Dear Sir,
Planning Application BE/33/19/HH
Conservatory to the side of 17 Frandor Road, North Bersted.

*Proposed Conservatory installation, frames white UPVC@
17 Frandor Road, Bognor Regis, PO21 5TP
Proposed Floor plan*

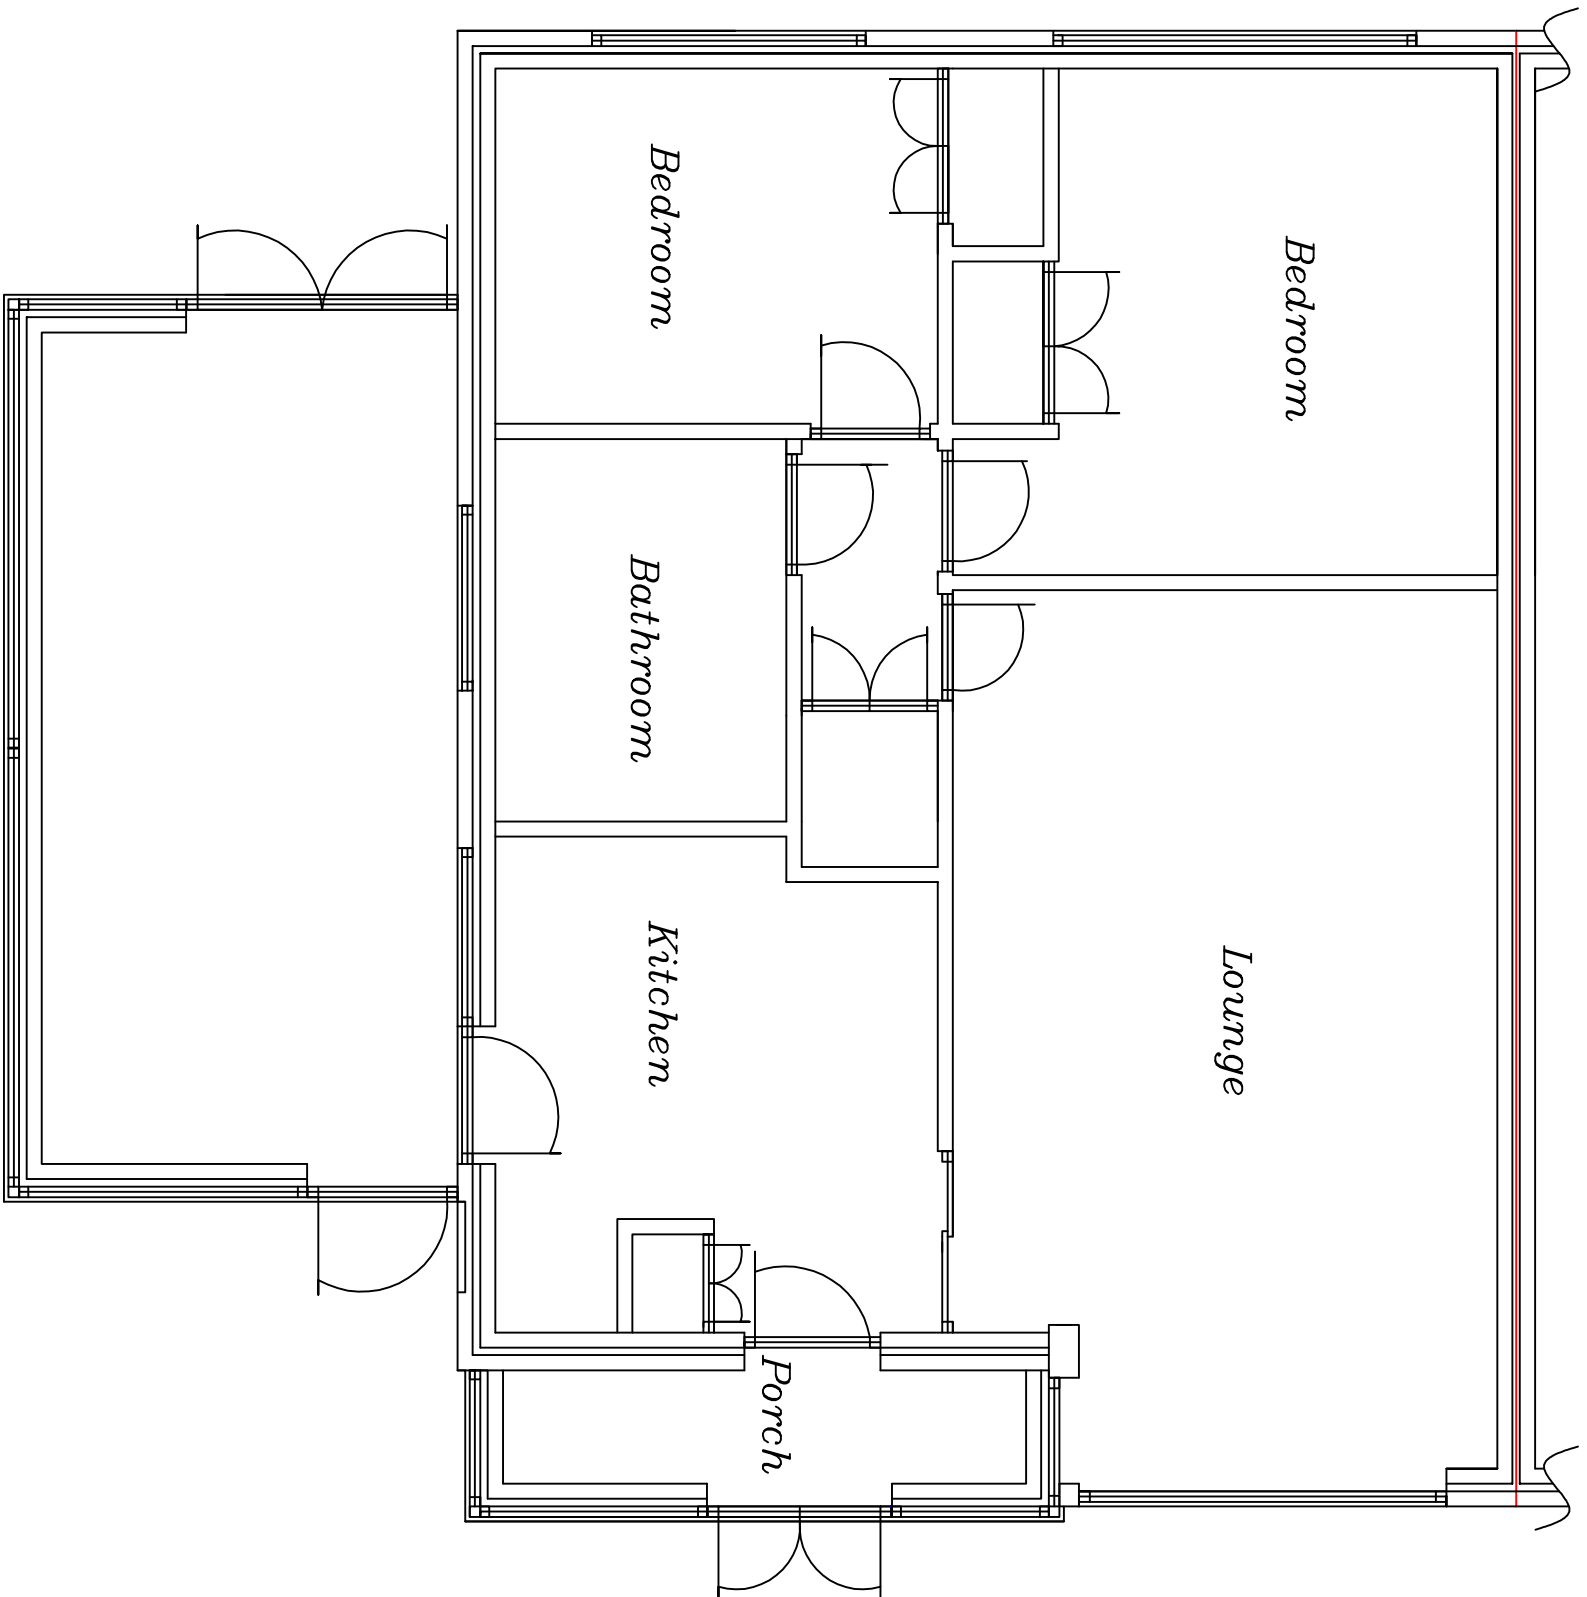
Firstly, the adjacent garage and driveway do not form part of the property, despite the red boundary line shown on the plan. The previous owner was a small time builder who refurbished the bungalow but sold the garage and driveway to a local landscape gardener, who uses the garage for the storage of equipment and other items. A Land Registry check may show this provided the builder carried out the necessary legal transfers (though somehow I doubt it.)

Secondly, the property's foul manhole will be contained within the proposed development and therefore I believe permission must be sought from Southern Water for any works in either adjusting the level of the cover or relocating

the chamber. As I suspect that this foul system serves a number of properties , including my own, the manhole should be inspected /tested to check for any possible damage due to the works and made good if required.
